EPC STORMWATER REVIEW COMMENTS
IN ORANGE BOXES WITH BLACK TEXT

STATE OF COLORADO
DEPARTMENT OF TRANSPORTATION
CITY OF COLORADO SPRINGS
Parks, Recreation and Cultural Services Department
CAPITAL IMPROVEMENT PROJECT
TRAIL IMPROVEMENT PROGRAM
COMBINED FEDERAL AID PROJECT No. TAP M240-162, SubAccT. No.20391
GRADING AND EROSION CONTROL
PLAN of the ROCK ISLAND MULTI-USE TRAIL
SAND CREEK TO CONSTITUTION AVENUE
COLORADO SPRINGS & EL PASO COUNTY, COLORADO

<p>IN PROGRESS NOT FOR CONSTRUCTION</p>	<p>1604 South 21st Street Colorado Springs, Colorado 80904 (719) 630-7342</p>	Sheet Revisions		90% BID SET	ROCK ISLAND TRAIL GRADING AND EROSION CONTROL PLAN COVER SHEET	Kiowa Proj. No. 16028
				No Revisions: Revised: Void:	Designer: RNW Detailer: RNW Date: 08/06/2024		TAP M240-162 SubAccT No. 20391 Sheet Number G1

Kiowa Proj. No. 16028
TAP M240-162
SubAcct No.20391
Sheet Number GEC 1

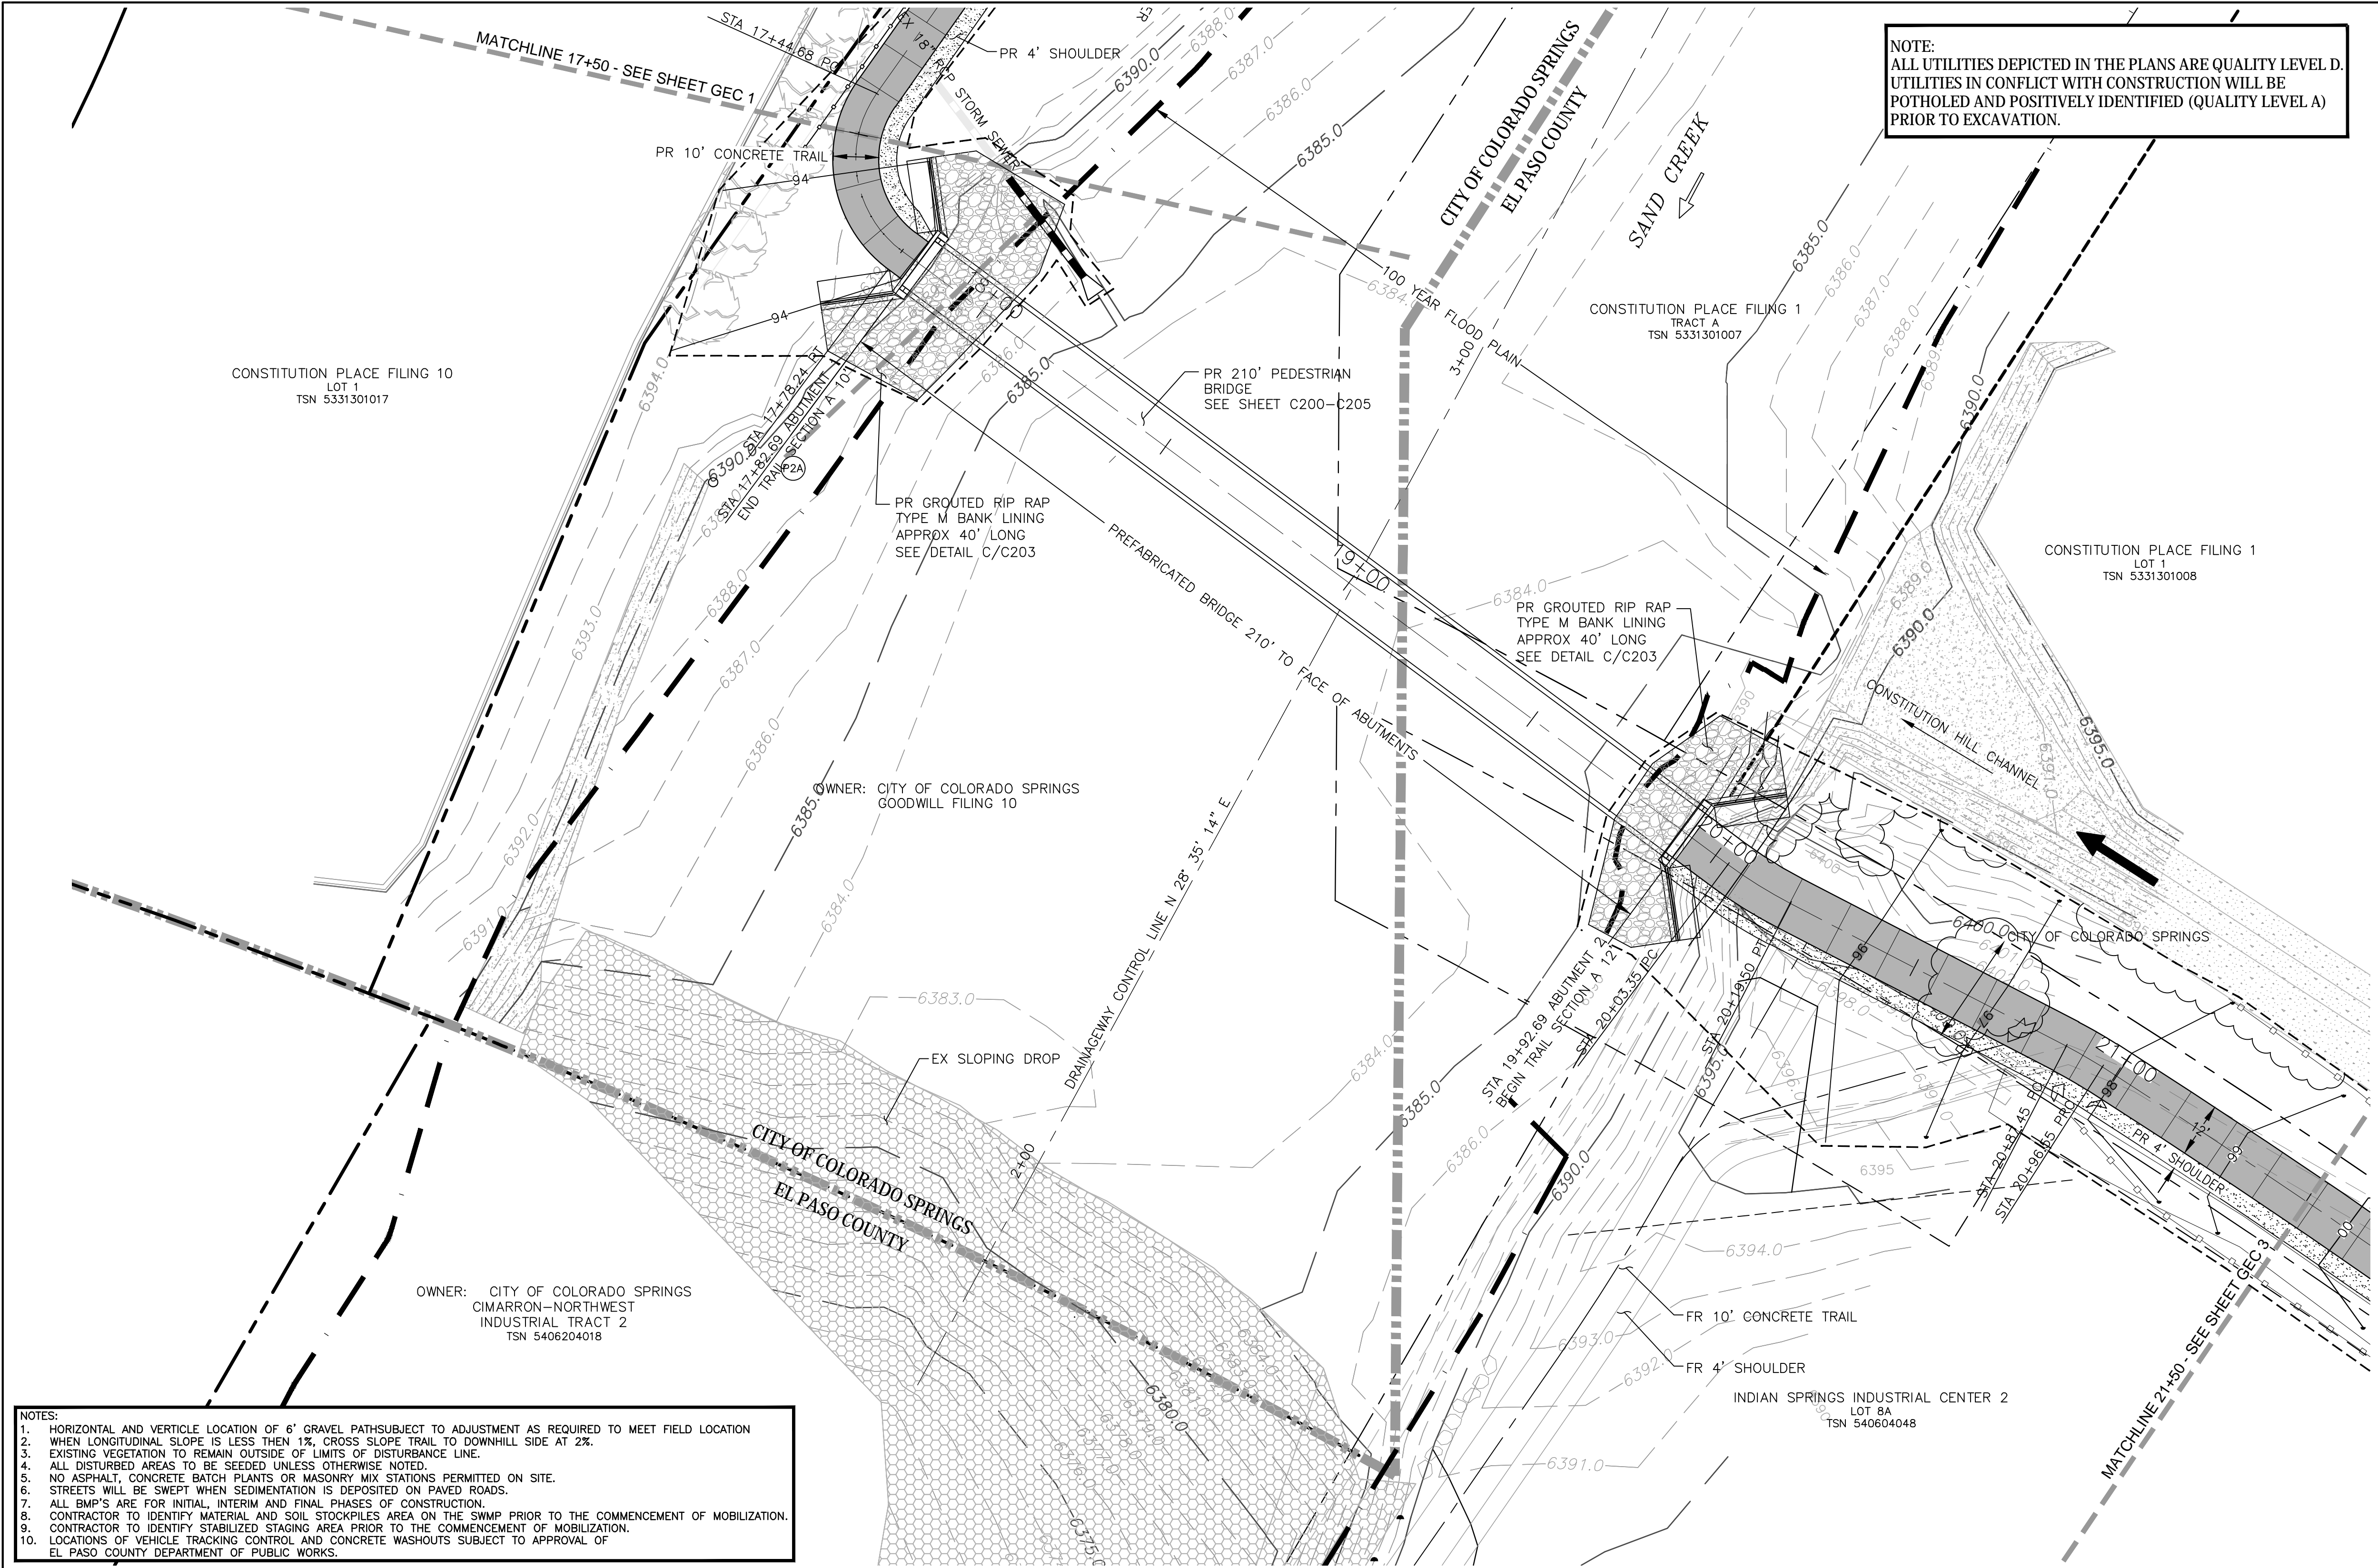
These construction sheets should also have BMPs, VTC, etc. These sheets don't appear to showing erosion control items. All items including flow arrows, cut/fill, BMPs, etc should be on all areas of disturbance.
